24/00045/FUL
25.01.2024

**RSA HOUSE, WESTERN ROAD, BRACKNELL, BERKSHIRE, RG42 1RX
SECTION 73 OF THE TOWN AND COUNTRY PLANNING ACT 1990: APPLICATION FOR A MINOR-
MATERIAL AMENDMENT IN RELATION TO PLANNING PERMISSION REF: 22/00879/FUL**

DRAWING NO. 19103 - SK32 REV -

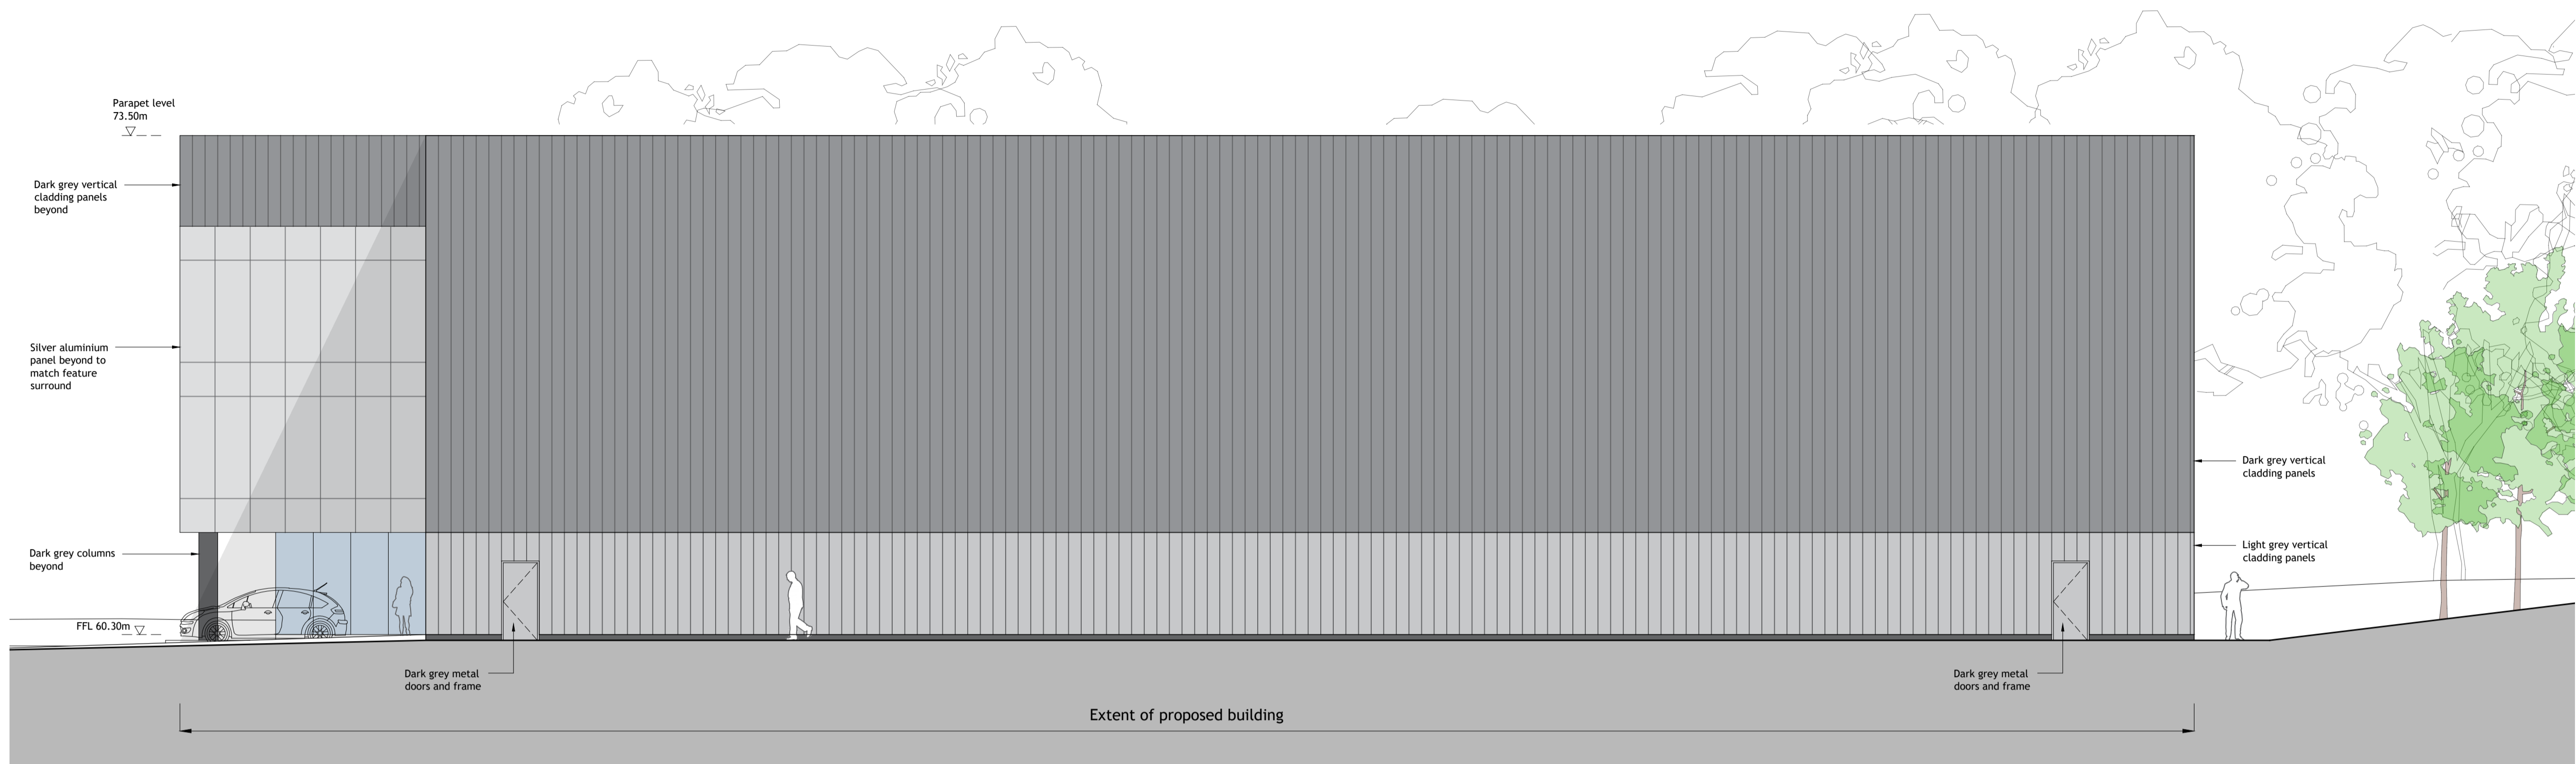
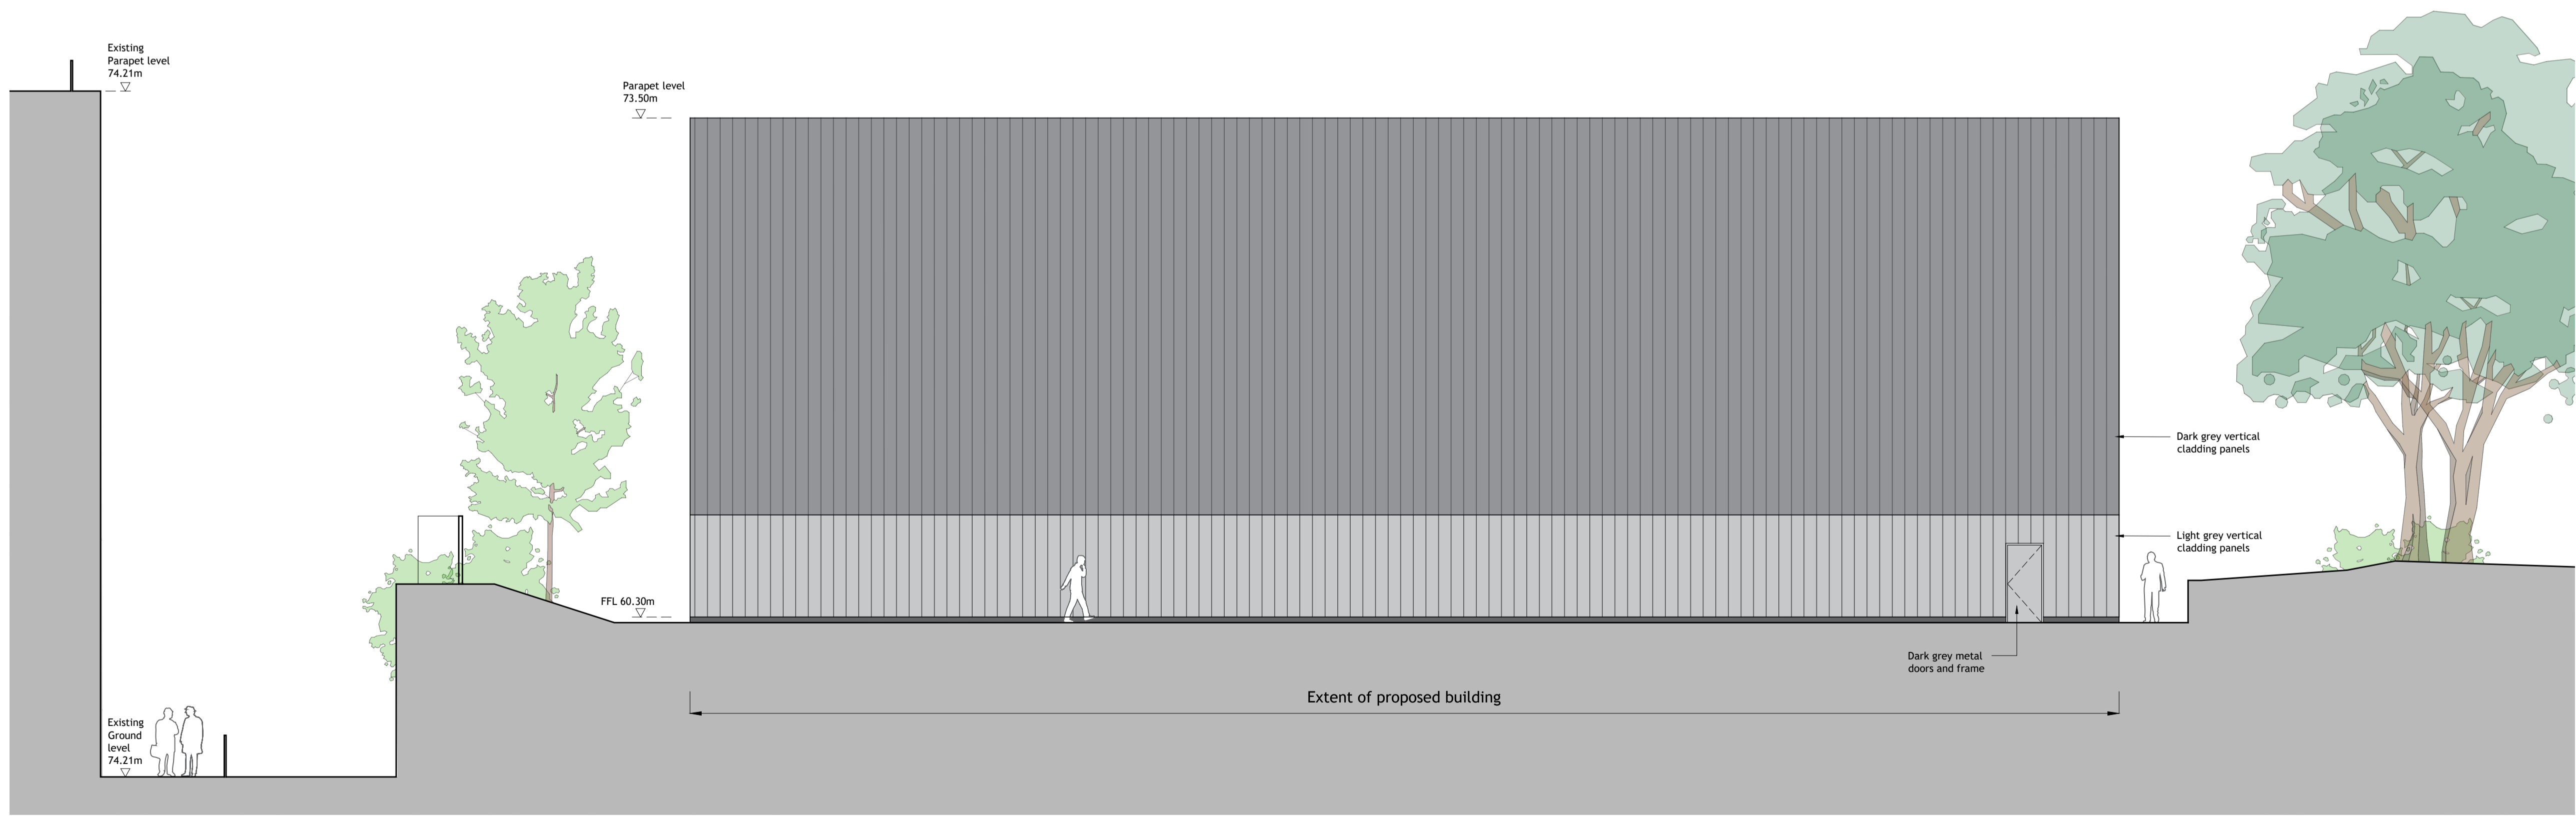
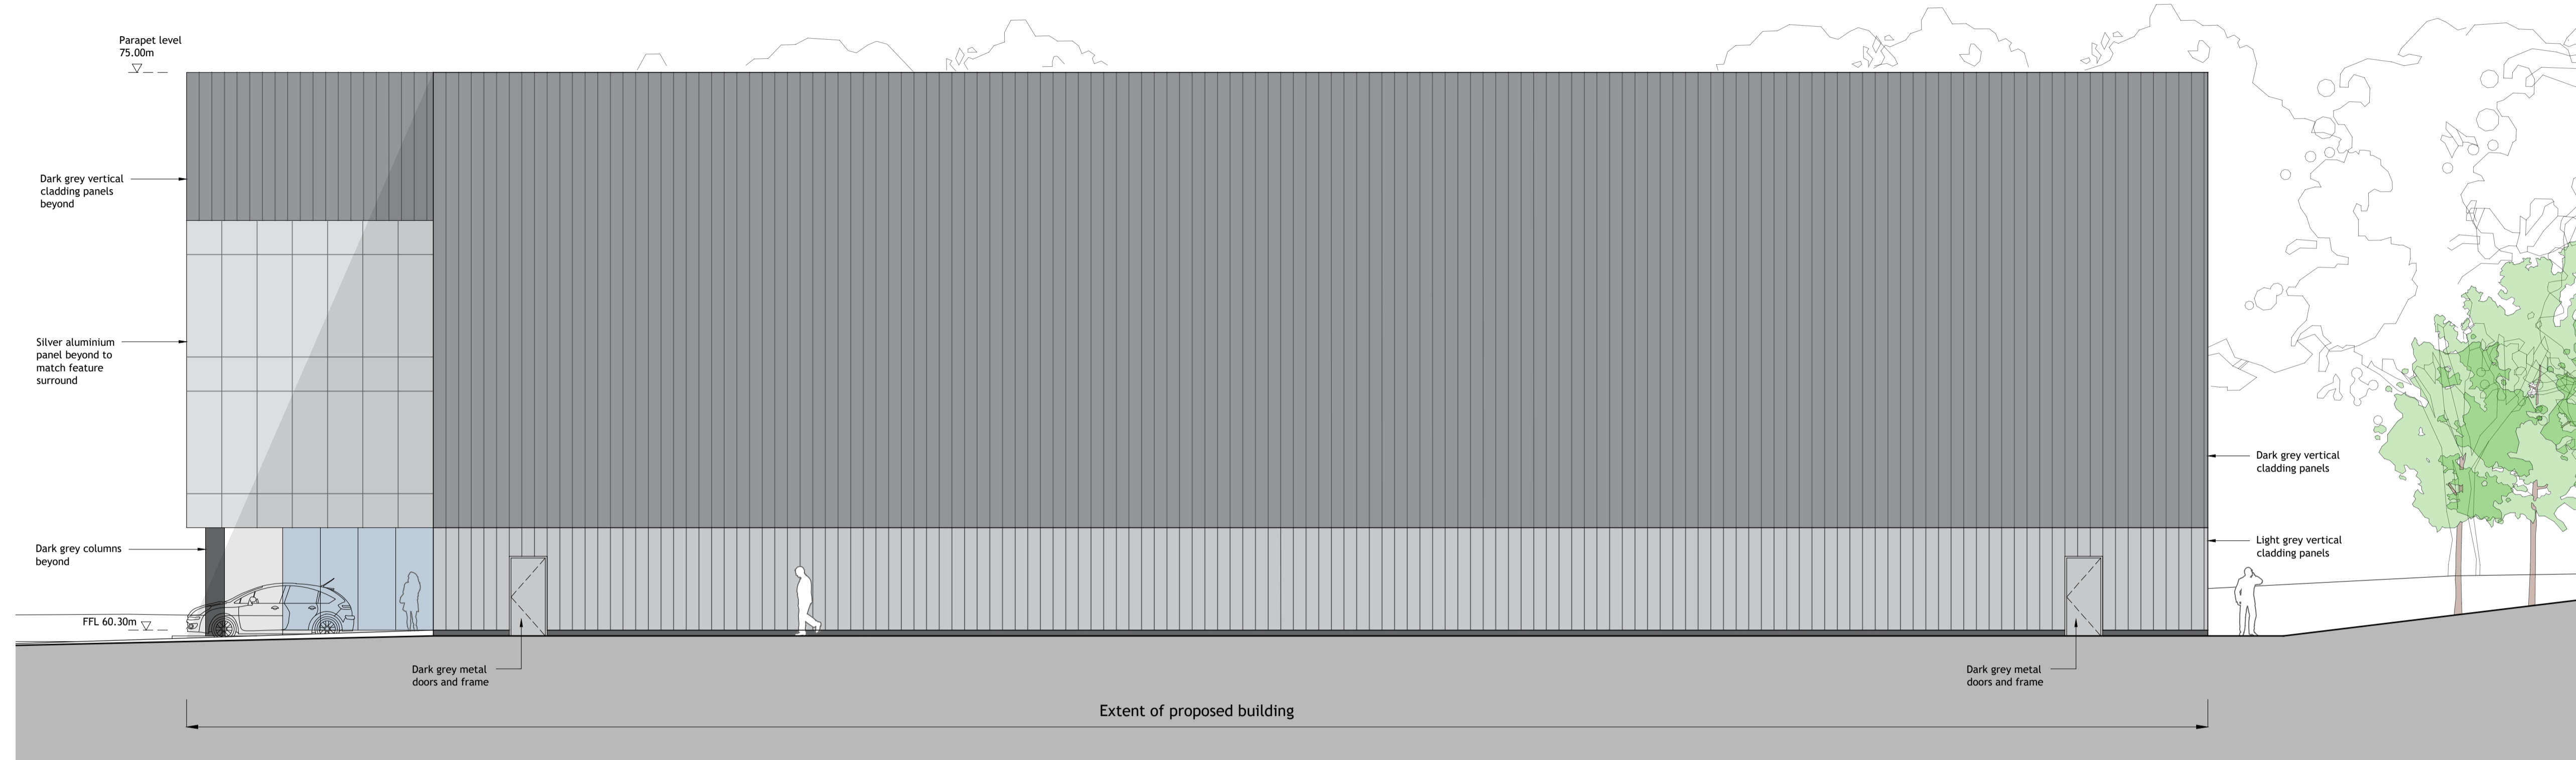
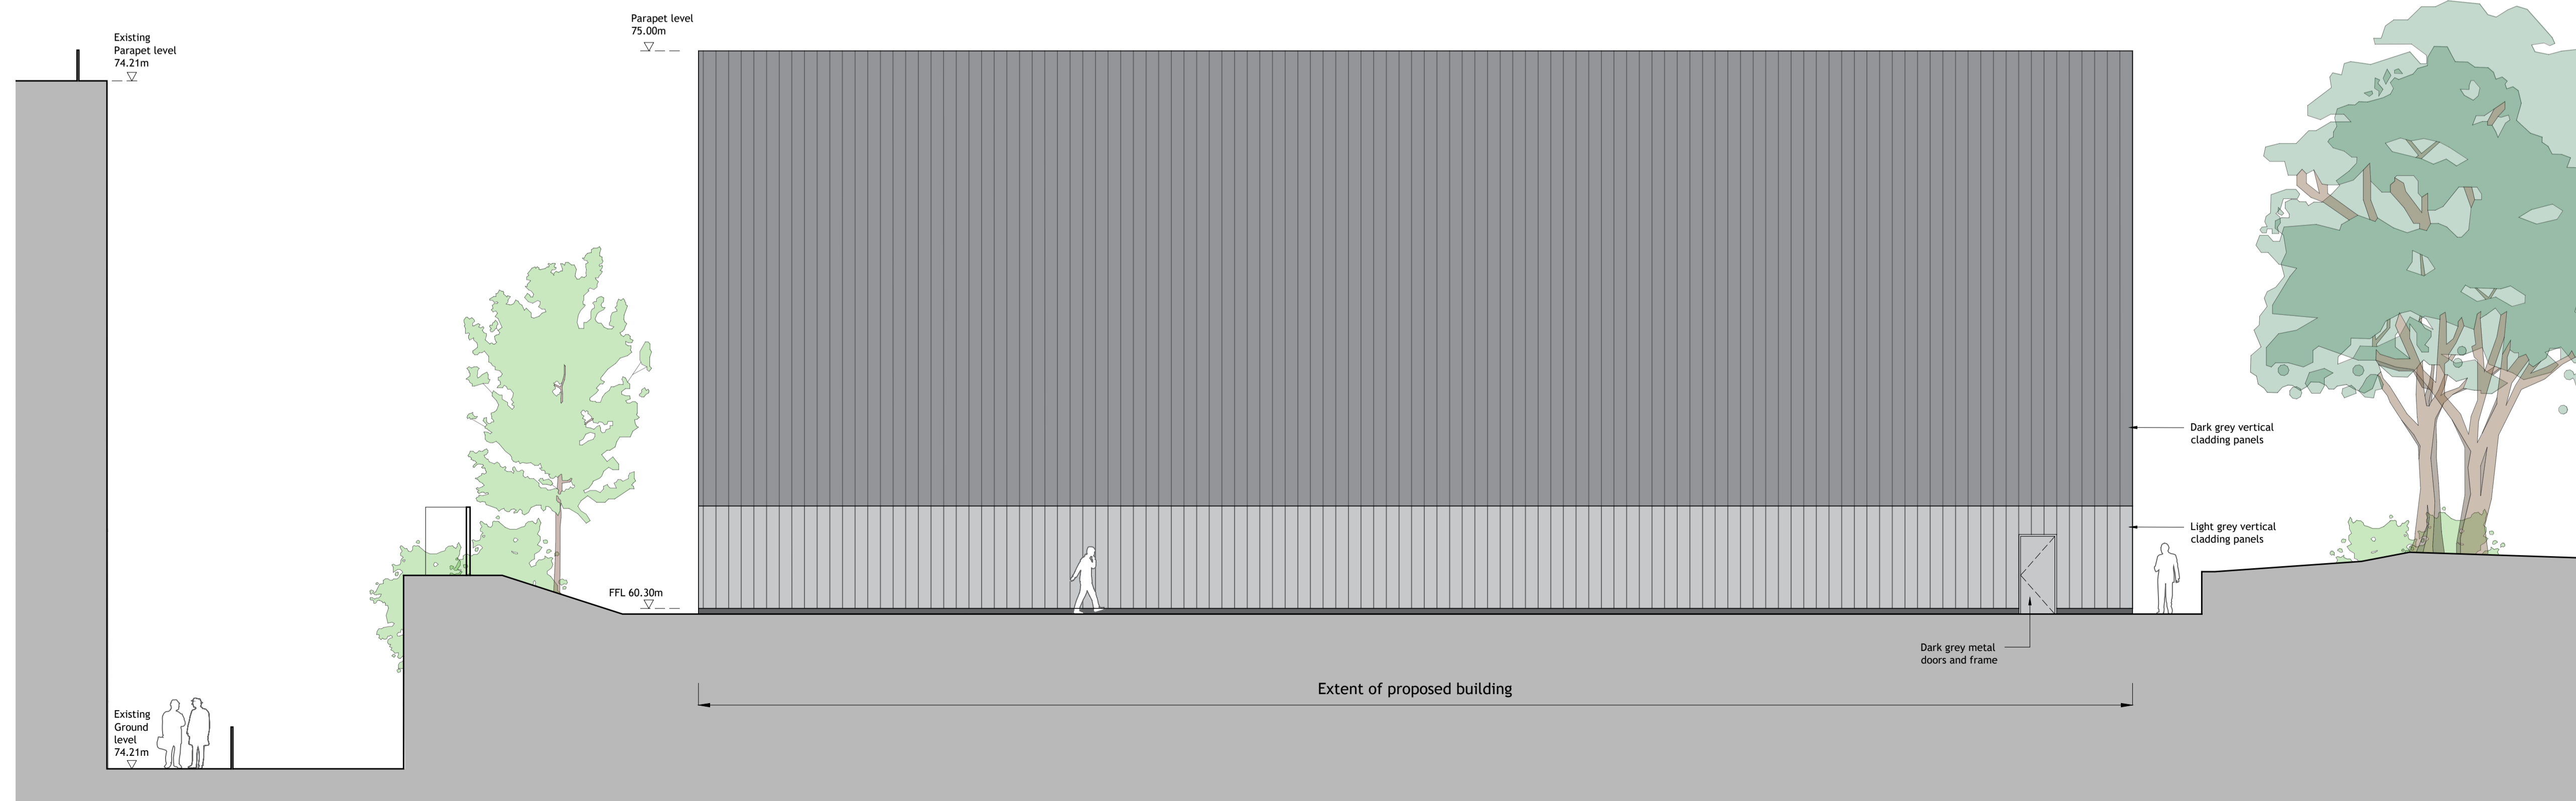
The Applicant has been marketing the Site to potential occupiers for a considerable amount of time with limited success. Tentative demand has emerged recently and the Applicant has engaged in comprehensive discussions with a potential occupier. However, as part of the discussions the potential occupier has stated they would require an increase in height of the building by 1.50m to progress discussions further, therefore taking the overall eaves height of the building from 13.2m to 14.7m.

Drawing Title	Approved Drawing Reference (drawings to now be superseded)	Proposed Drawing Reference (to supersede Approved Drawings)
Proposed Site Sections	19103-SK29 Rev A	19103-SK34
Proposed Elevations	19103-SK30 Rev B	19103-SK35
Proposed Elevations	19103-SK32	19103-SK36

In the context of the above, it is considered the proposed 1.50m increase in height of the approved scheme represents a ‘minor material amendment’, and therefore, under Section 73 of the Town and Country Planning Act 1990, an application to vary the conditions under the approved decision notice represents the most appropriate planning route.
